MEMORANDUM

TO: Shukria Wiar, Planner
FROM: David Senus, PE
DATE: September 3, 2015
RE: 35 Pleasant Street Renovation, Final Level II Site Plan Review

Woodard & Curran has reviewed the Final Level II Site Plan Application for the proposed renovation located at 35 Pleasant Street in Portland, Maine. The project involves an internal renovation and a garage addition over an existing parking lot.

4 Upper roof drainage plan  
1/4" = 1'-0"

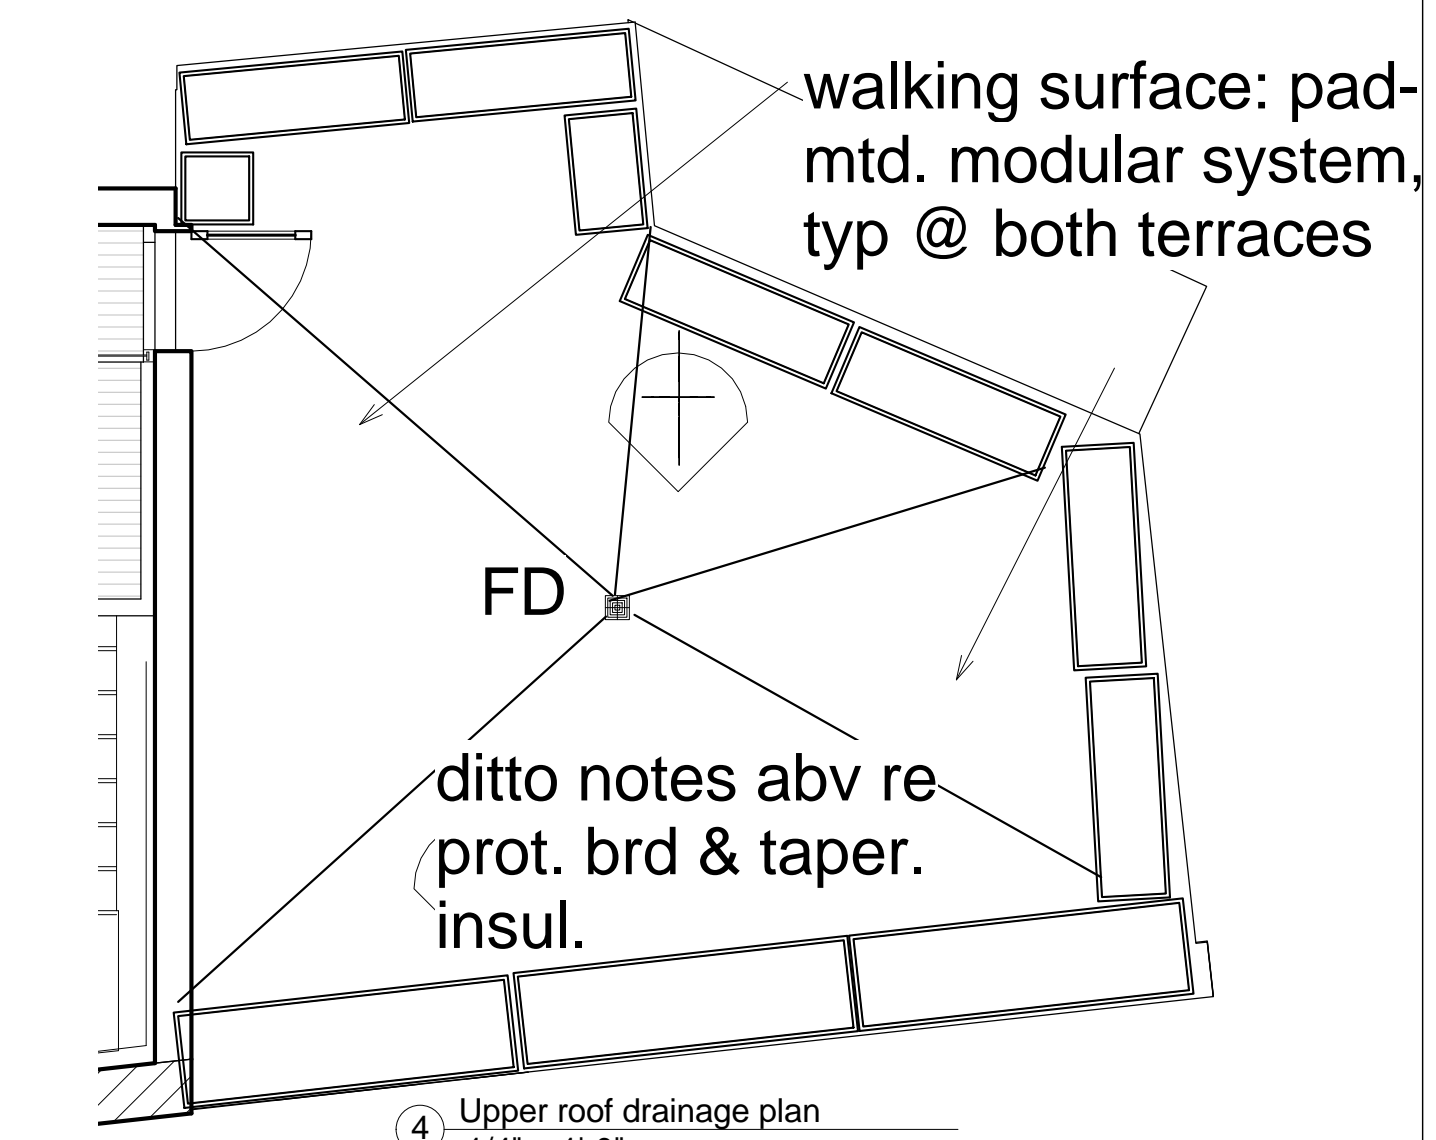
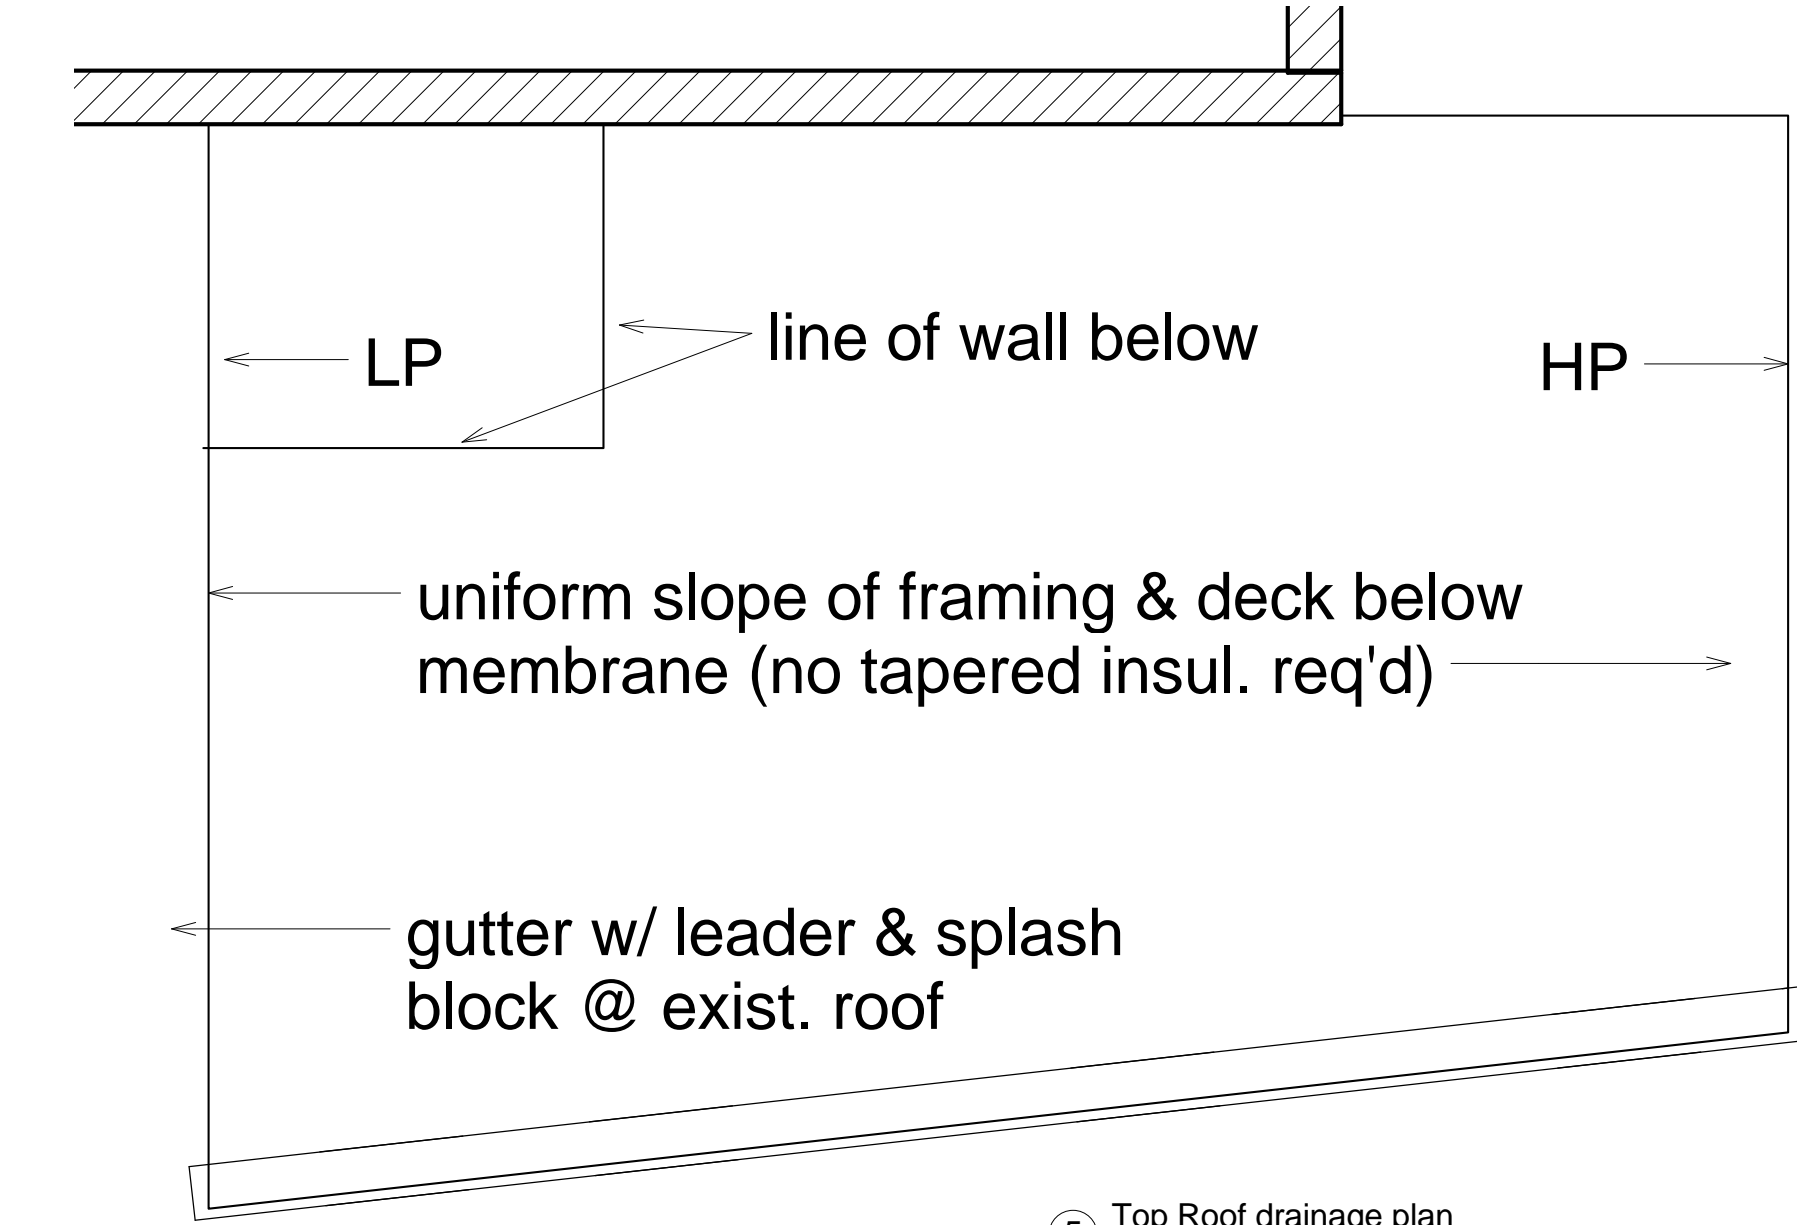
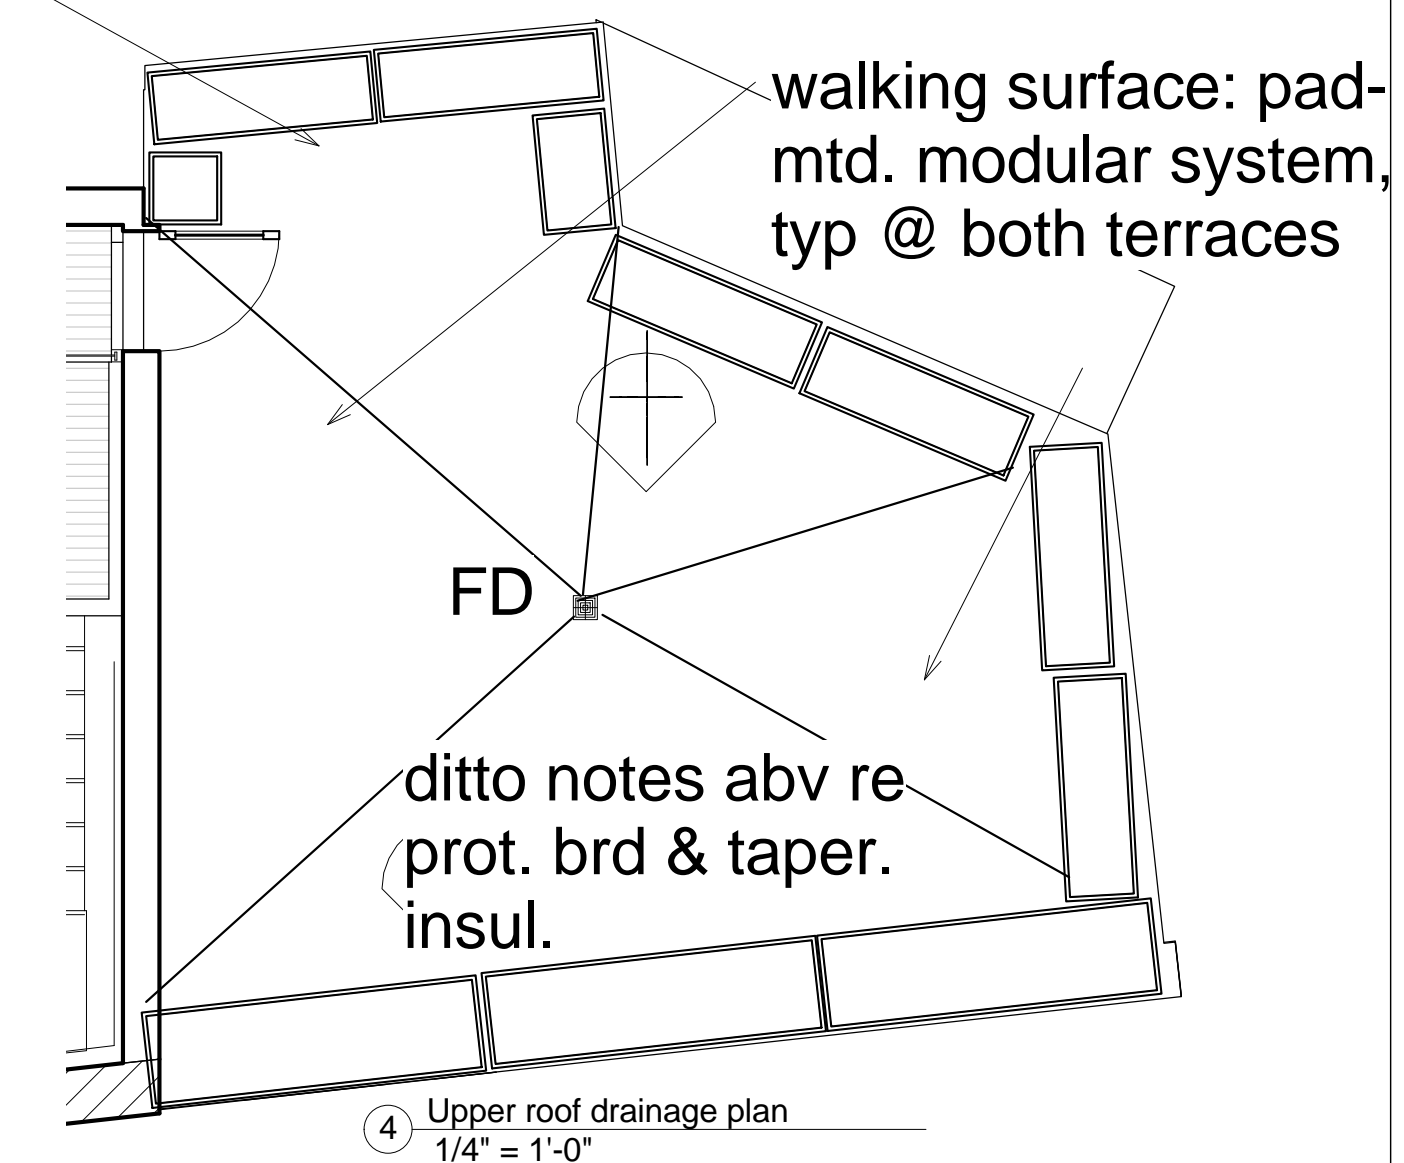
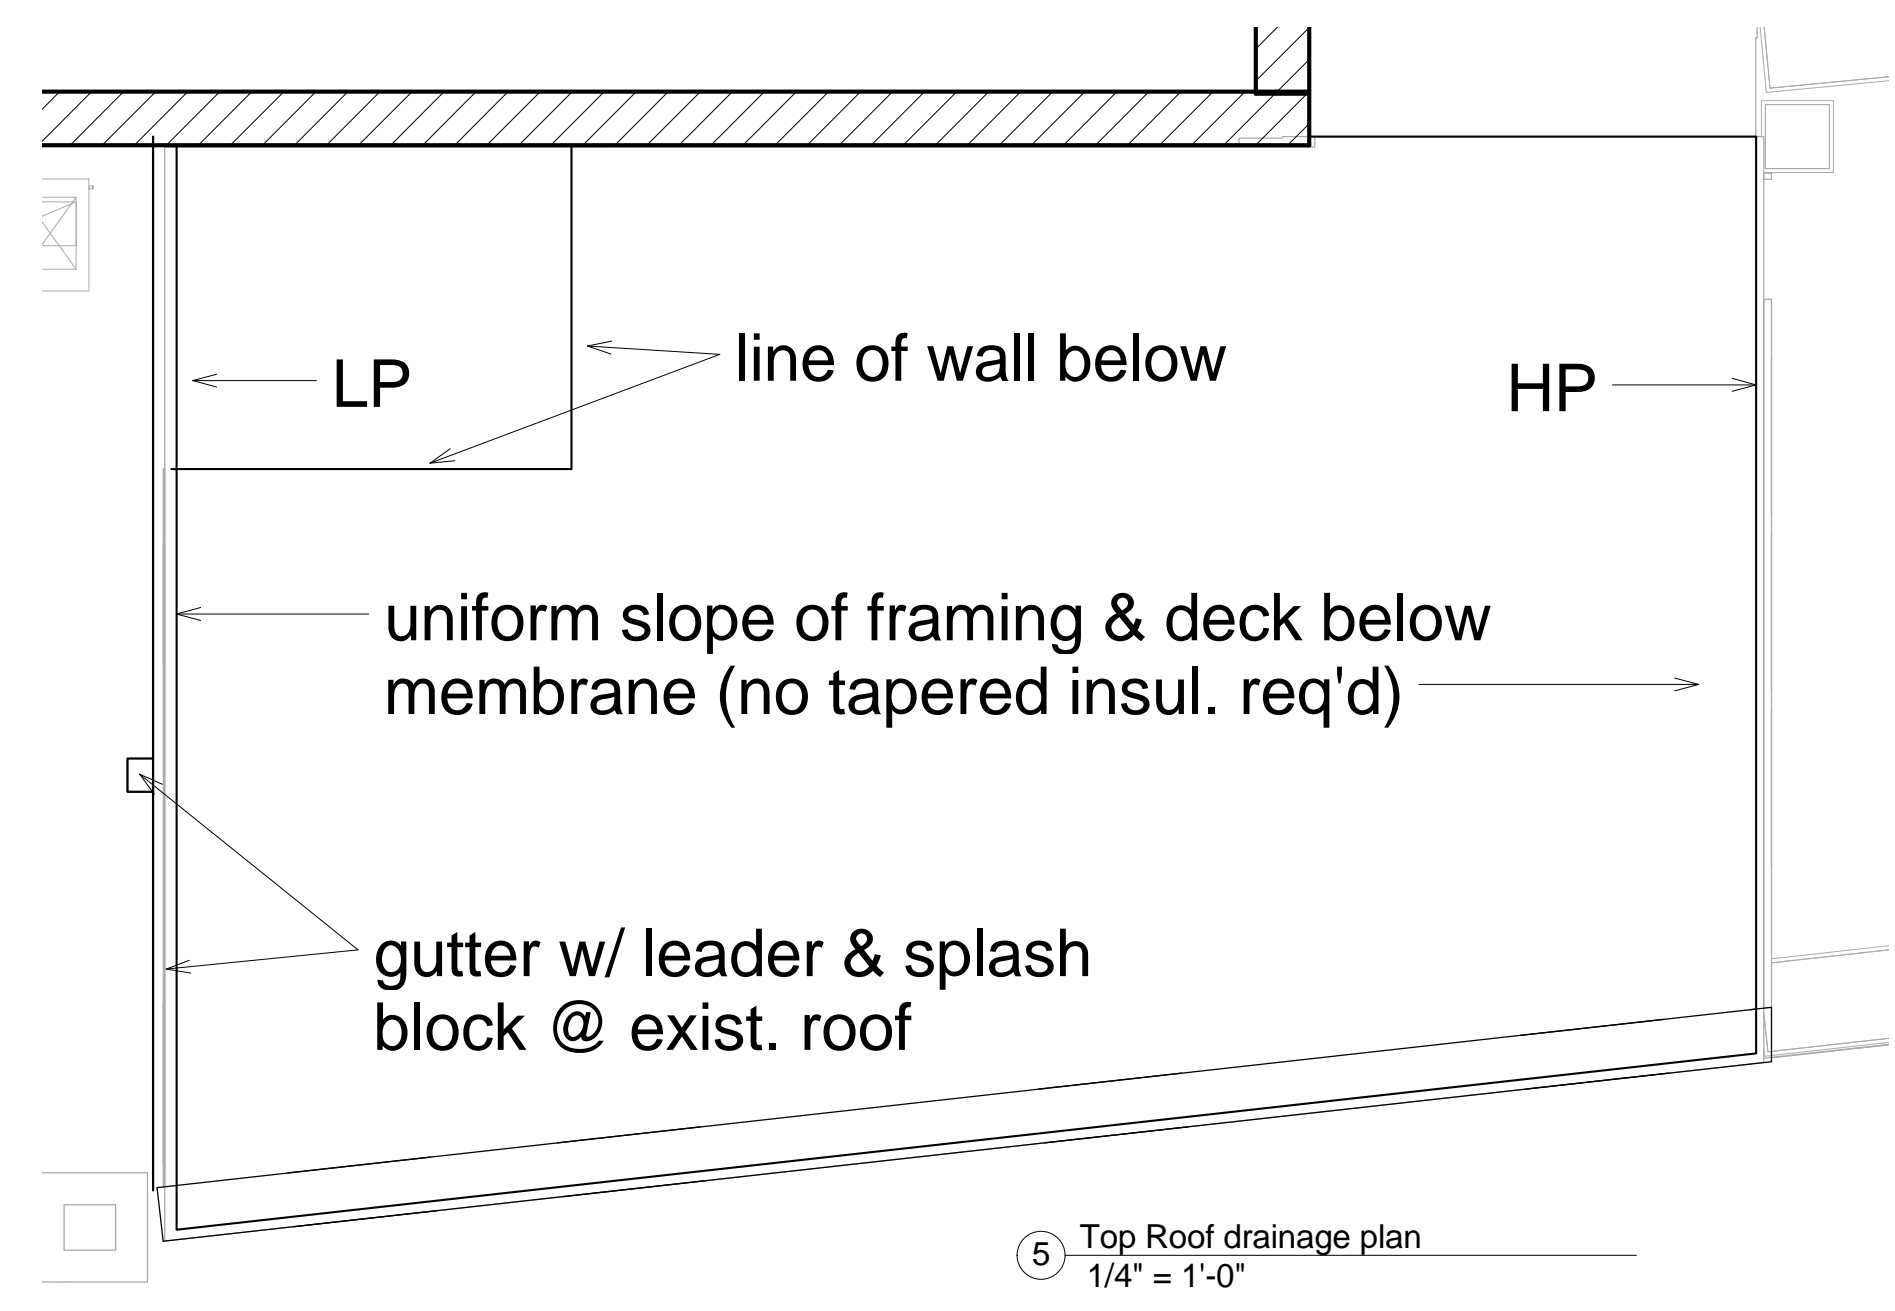
- 1) The Applicant has noted that an updated survey will be submitted showing topography in the parking area/area of the addition, and the location/elevation of a storm line connection point. If the proposed storm line is associated with roof water, the City DPS may prefer that the pipe discharge to the street in lieu of a direct connection to the combined sewer; the Applicant should verify through David Margolis-Pineo at the Department of Public Services. The Applicant should note that details will be necessary for all work within the Right-of-Way in accordance with the City of Portland Technical Manual (such as sidewalk repairs, pipe trench, etc).
